MP 08_0241 MOD 2 – 100 Mount Street, North Sydney

The NSW Department of Planning & Environment have prepared draft conditions of approval and issued these to the Proponent requesting a response. We write on behalf of the Proponent Laing O'Rourke Mount Street Pty Ltd, in response to the draft conditions. The response to the draft conditions is provided with reference to the conditions, as follows:

Ground Floor Plan

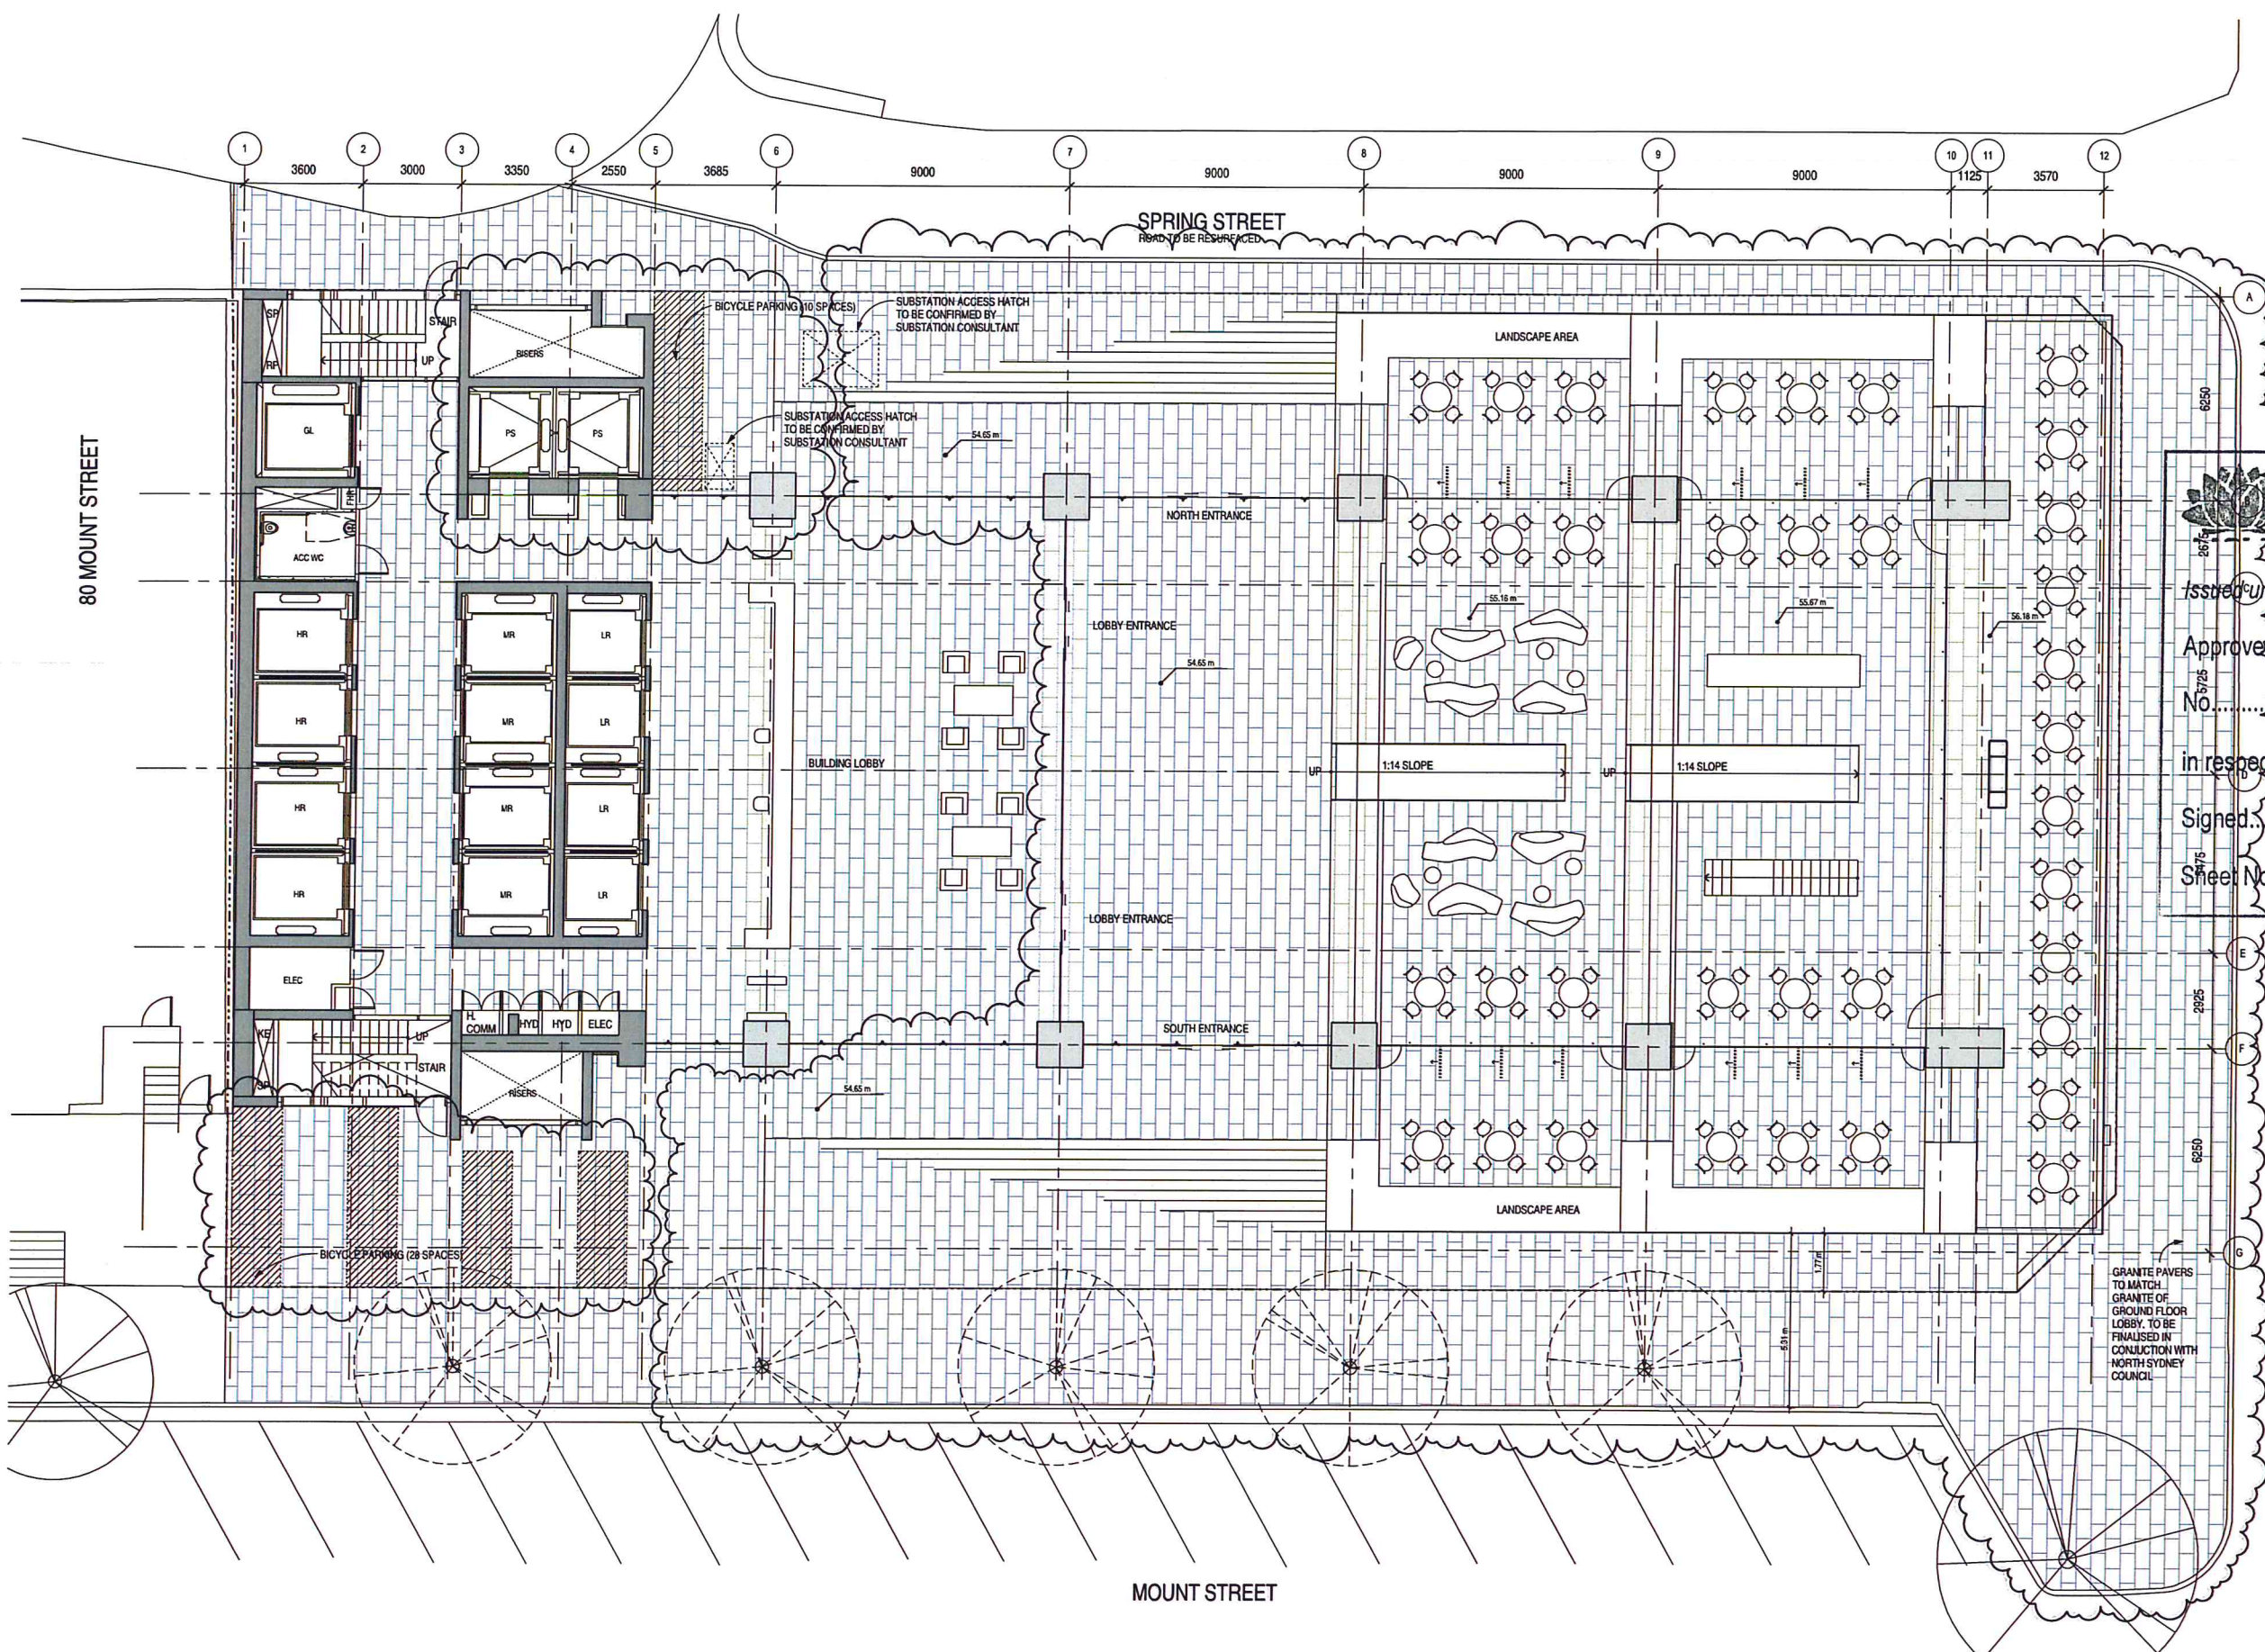
The bike parking on the ground floor plan, at Mount Street and Spring Street, is to be consistent with designs indicated in the North Sydney Public Domain Style Manual and installed in accordance with AS289.3 and other relevant codes of practice. The bike parking design must be submitted to Council for approval by Council’s Manager Traffic Planning”.

The condition should be amended to refer to Australian Standard AS2890.3.
